DELEGATED HOUSEHOLDER DECISION

15 BLACKPOOL GARDENS HAYES

Erection of a single storey rear extension, double storey side/rear extension and conversion of roof space to habitable use to include a rear dormer and three front roof lights.

SCALE AT A2:	DATE:	DRAWN:	CHECKED:
1:100	30/03/23	QR	GB
PROJECT NO:	DRAWING NO:	REVISION:	
22173	AD-13	A

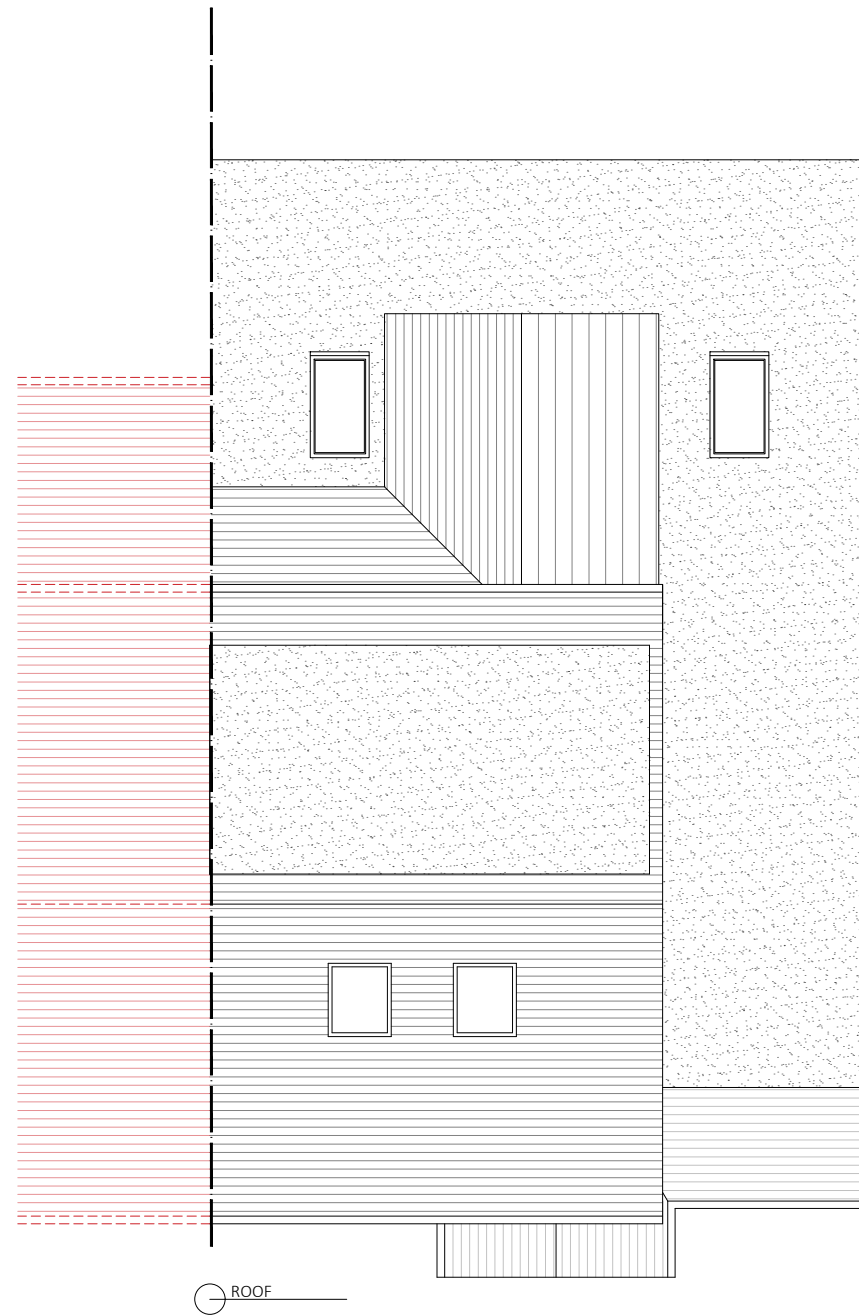
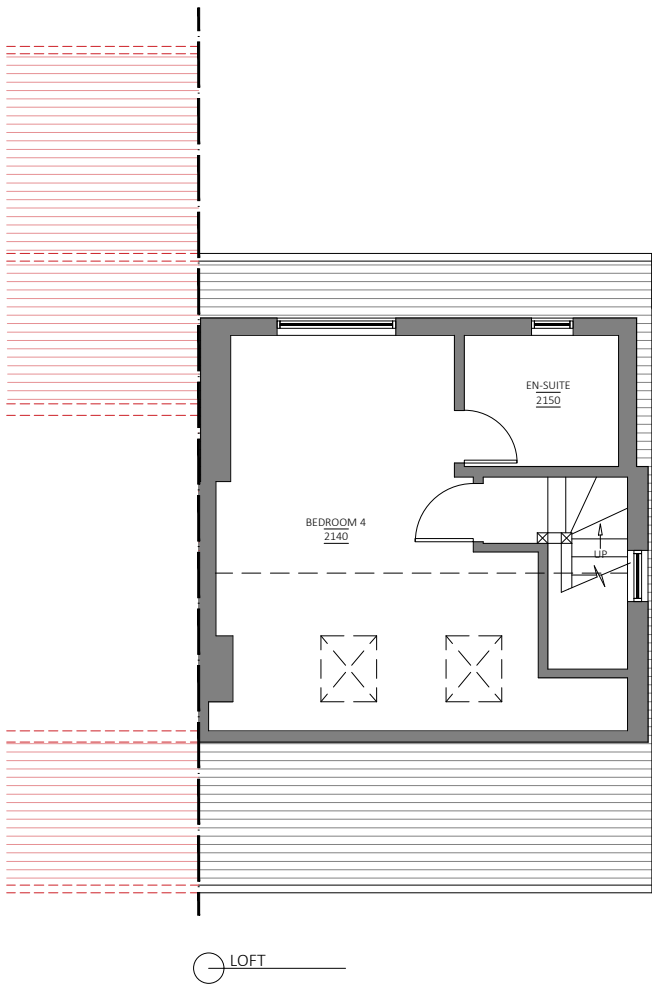
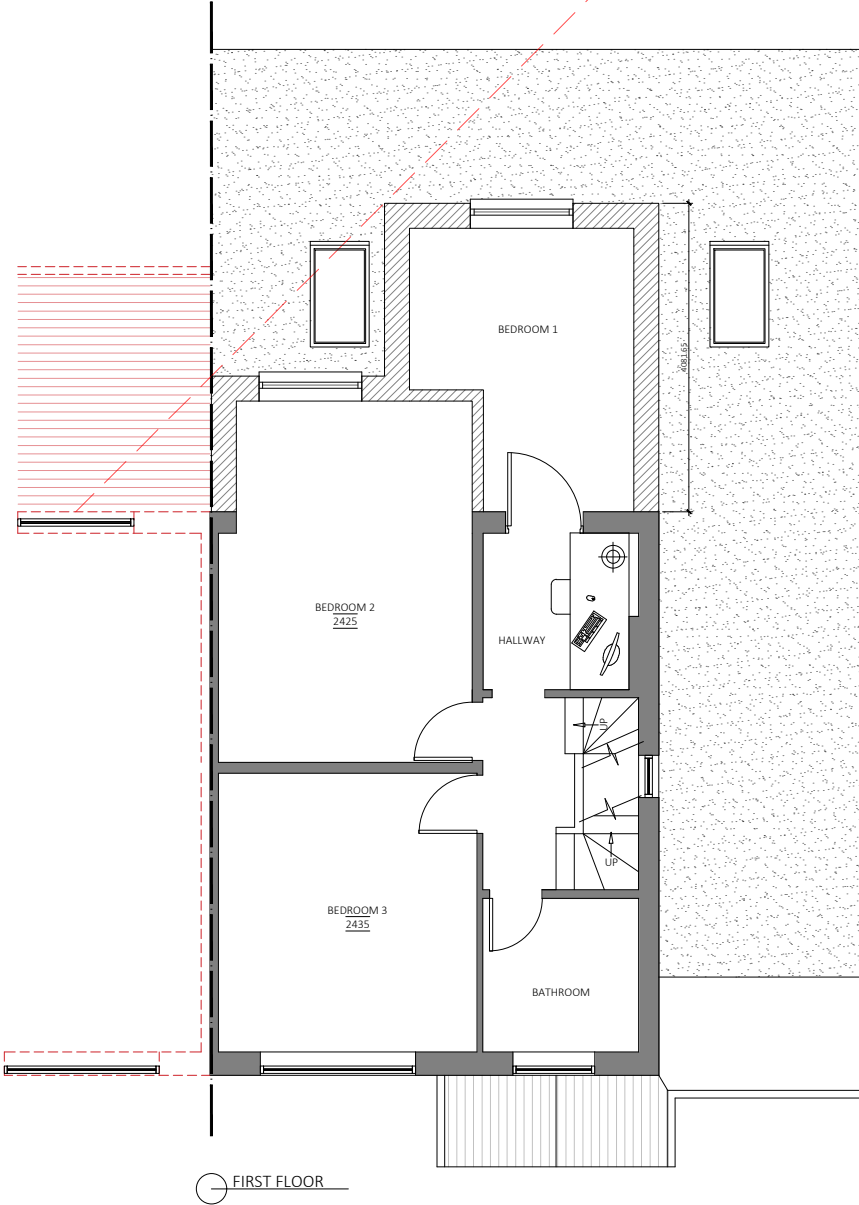
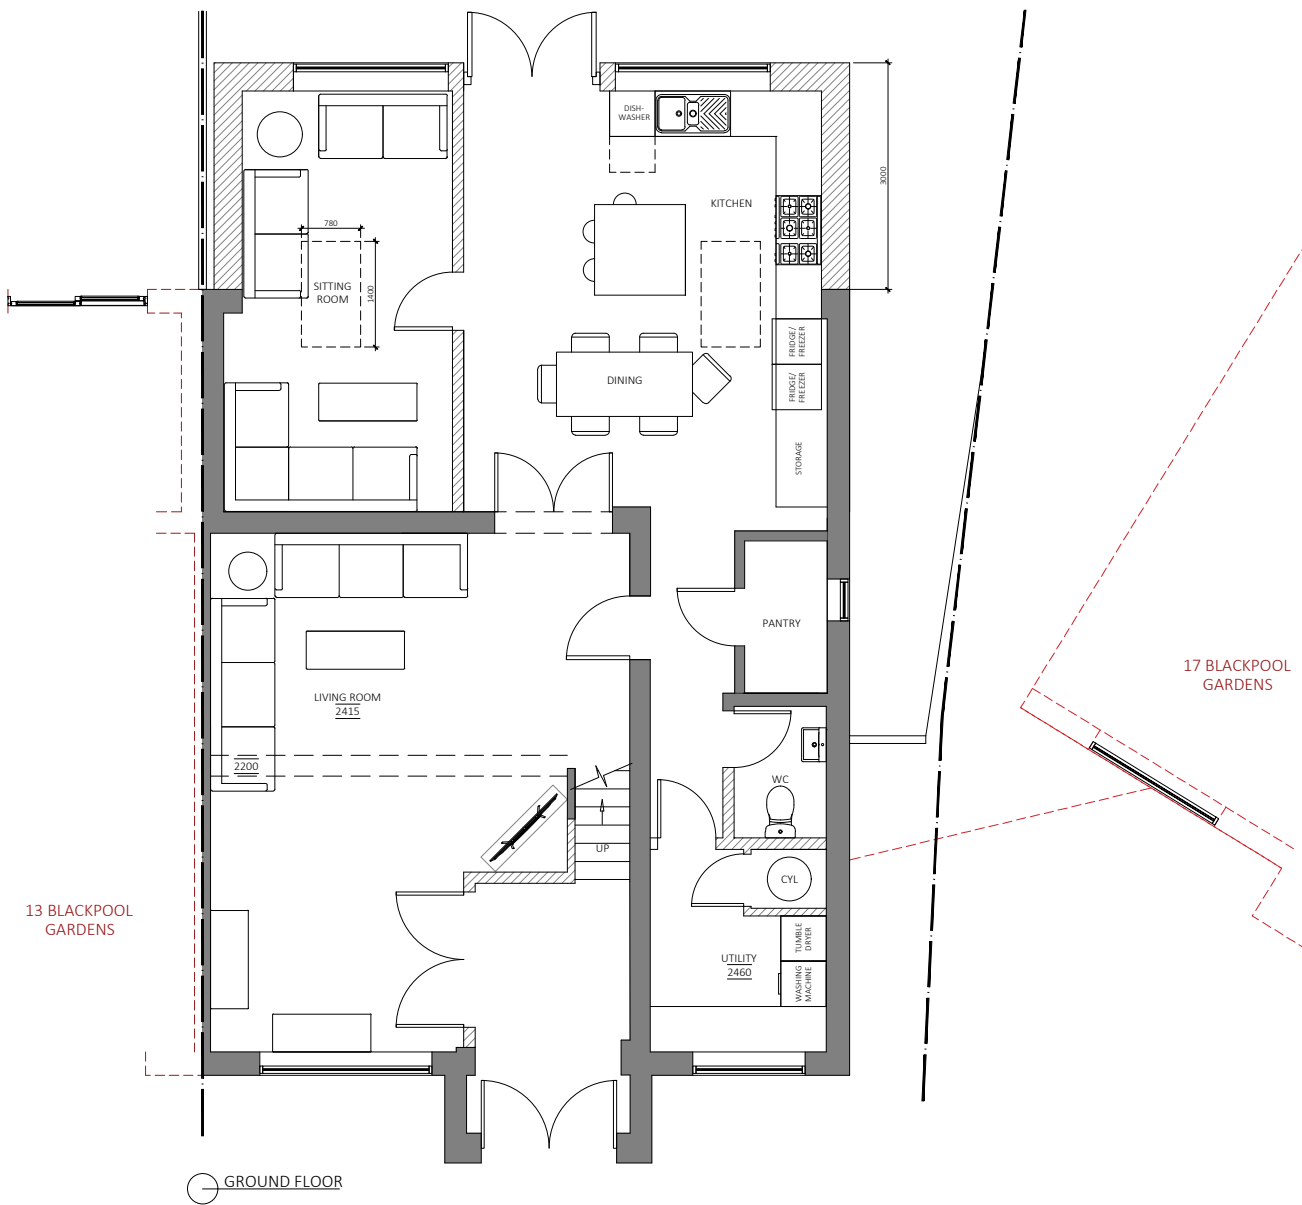
The extension would be 3M deep from the existing rear elevation but more than 3m from the original rear elevation and as such would not comply with Council's policy guidelines. Nonetheless, the proposed single storey element would be 6m from the original rear elevation which is not excessive. It would be subordinate in height, scale and mass to the main dwellinghouse and given its rear location, there would be no significant impacts on the wider area as it would not be visible from the street scene and extensions are common within the locality. With regards to the first floor rear extension, the proposed depth of 4M marginally exceeds the Council's prescribed guidelines on depth for rear extensions. However, the rear extension would remain subservient to the main dwelling and would have minimal impacts in terms of character and appearance given its rear location. The first floor rear extension would be set well beneath the main roof and would integrate well with the existing dwellinghouse.

The application proposes the retention of the existing rear dormer and no. 2 front roof lights. The dormer measures a length of 5.34M, 2.34M high, has a projection of 3M and is set beneath the roof ridge by 0.3M. The dormer is visibly set in from the roof slope and set adequately above the eaves line. Consideration is given to the fallback position of permitted development. The subject property could extend the roof up to 40 cubic metres in volume under Class B of Part 1 of GDPO. The submitted plans confirm compliance with the conditions set out in Class B of the GPDO and this is material in the consideration of the application. In this regard, the proposed dormer would appear relatively subservient to the proposed roof slope. It is not considered that the proposed rear dormer would appear out of character in the context of the residential street scene.

To No. 13 Blackpool Gardens, the proposed rear extension extends 3m beyond the neighbour. At this depth, it is considered that the single storey element would not result in undue loss of light, overshadowing or overbearing effects. The proposed first floor element would be set off the shared boundary by 2.3M and the proposed plans illustrate that the 45 degree angle would not be exceeded when measured to the centreline of the nearest habitable room which is a bedroom. As such, whilst there would be some impact, it is not a significant loss of outlook, overbearing or loss of light for the nearest habitable room and no objection is raised.

Whilst the windows in the rear dormers will be opening fixtures, they are considered located at a sufficient distance from the neighbouring properties to the rear of the dwellings and as such, the impacts are considered minimal.

The proposed development would retain approximately 236 square metres of rear garden space. As such, the proposal would not undermine the provision of external amenity space for the existing occupiers at the site, in accordance with Policies DMHD 1 and DMHB 1 of the Hillingdon Local Plan: Part Two - Development Management Policies (2020).

The resultant proposal would retain two off-street car parking spaces to the front of the application site. The proposal would, therefore, not significantly exacerbate the demand for street parking or prejudice highway safety, in accordance with DMT 6 of the Hillingdon Local Plan: Part Two - Development Management Policies (2020).
